**From:** Simon Davis  
**Sent:** 18 January 2021 16:03  
**To:** Havis, Sean [REDACTED]  
**Cc:** Sparkes, Jessica [REDACTED]  
**Subject:** RE: \*EXTERNAL: Y/127/20/PL Standalone Application for the Access

**From:** Simon Davis <[Simon.Davis@arun.gov.uk](mailto:Simon.Davis@arun.gov.uk)>  
**Sent:** 12 January 2021 16:23  
**To:** Havis, Sean [REDACTED]  
**Cc:** Sparkes, Jessica [REDACTED]  
**Subject:** RE: \*EXTERNAL: Y/127/20/PL Standalone Application for the Access

Drawing Title
SECTION 278
GENERAL ARRANGEMENT
AND PROPOSED
LEVELS PLAN

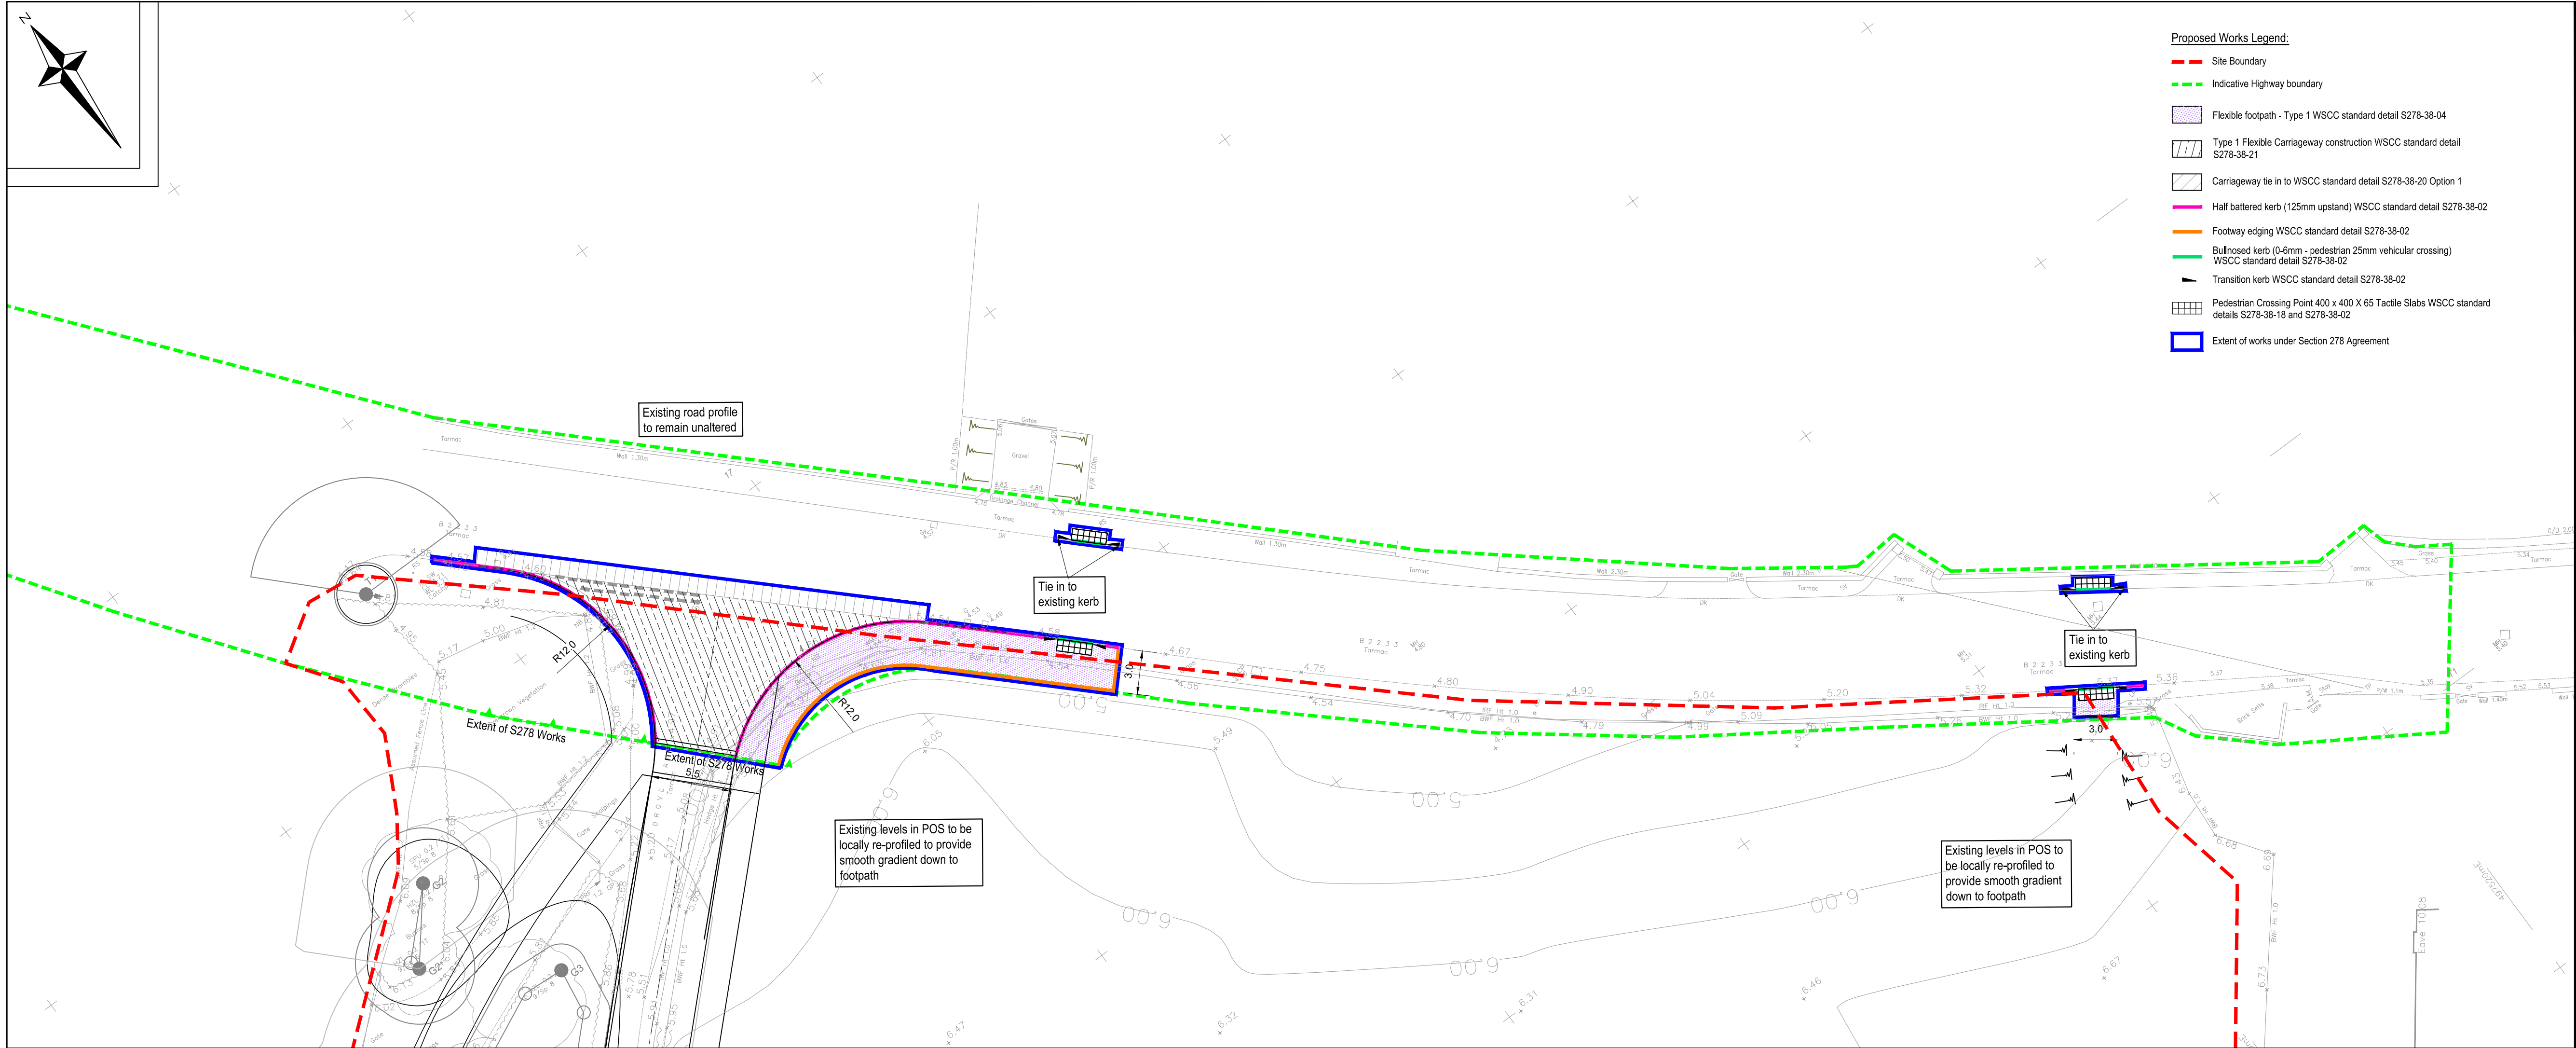
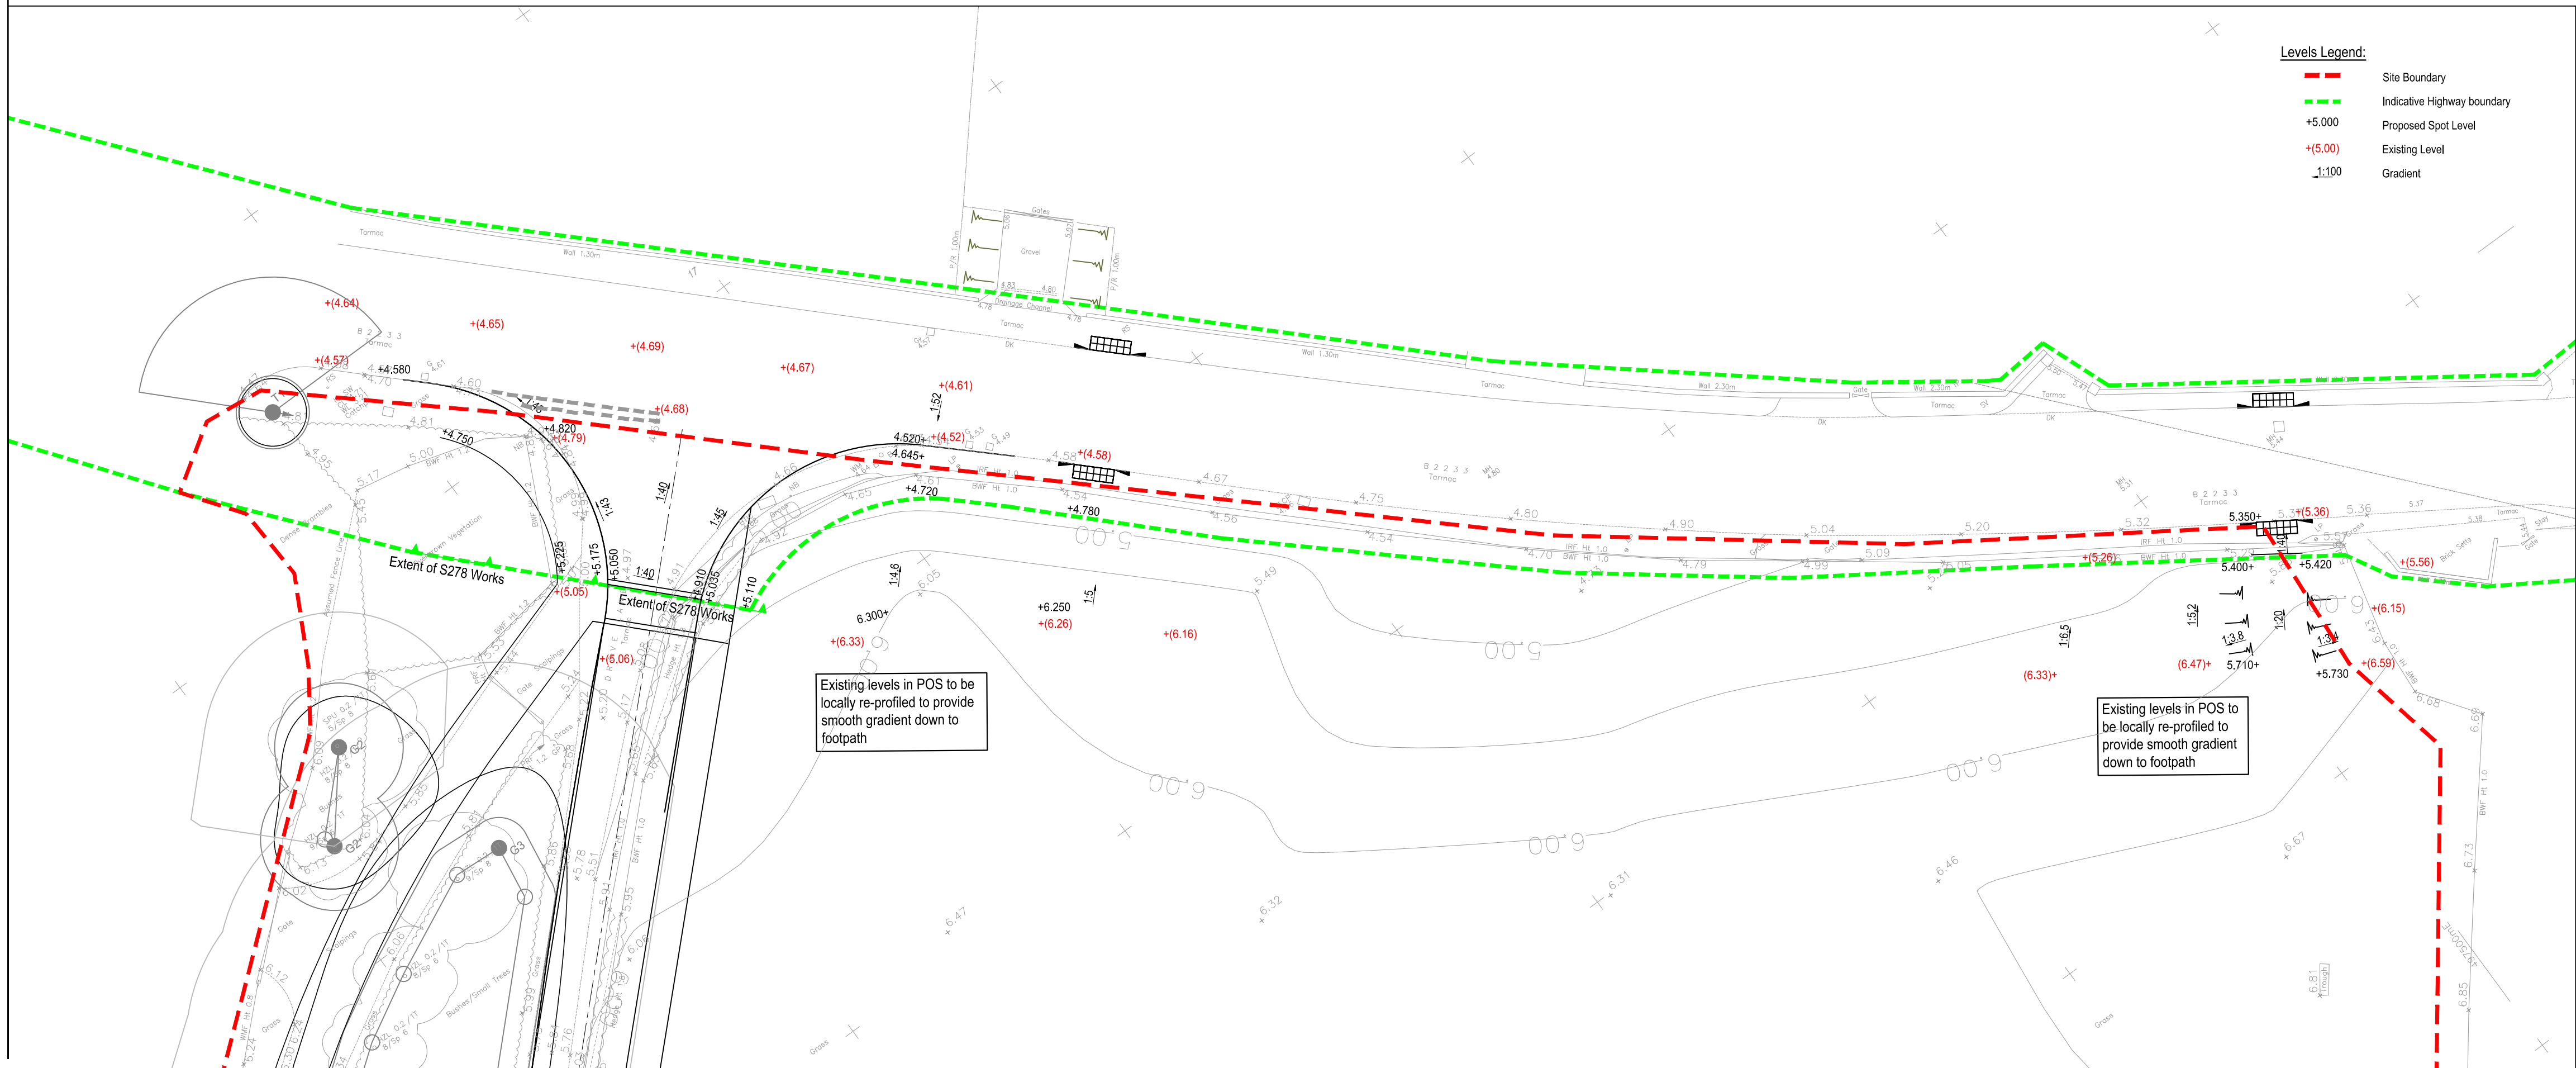
There is a concern that the access arrangements make no provision for cyclists to cross Main Road at the point where the cycle/footpath meets the highway (this point being directly opposite the vehicular access to the Bonhams Field site).

My feeling was that cyclists could safely cross the road by heading south at the end of the cycle path, crossing over Drove Lane and then using the tactile paved crossing point to cross over onto the pavement on the eastern side of Main Road. However, there is concern that cyclists, particularly children, will not do this and may instead just try to cross over straight into the Bonhams access with a risk of accident.

Pages 24-25 of the West Sussex Cycling Design guide does address the issue of the interface between the carriageway and a cycle path. It states that cyclists should not have to dismount to cross roads and that barriers should only be provided where there is a need and it recommends that a single bollard is sufficient.

Is there a reason why you have deviated from the alignment of the cycle path as shown on the outline access plan? This previously showed the cycle path meeting the carriageway with two bollards (attached for ease). That arrangement would still have been opposite the Bonhams access but does better meet the Cycling Design guidance.

The proposed access has been designed in discussion with WSCC and has received technical approval. Due to the access that will be constructed opposite to serve a different development, a crossing point could not be provided due to conflict of junctions. Instead we are proposing to direct cyclists on to the B2233 with appropriate warning signage and dropped kerbs. This has been through the technical approval process and in consultation with the Road Safety Audit process, all of which is now technically approved.

I hope that is satisfactory in explaining why the plan has deviated from the outline application and also confirms that it has been designed alongside WSCC and meets all the necessary technical approvals and safety audits.

It is our intention to supersede the approved plan via a Section-73 application once this application is decided.
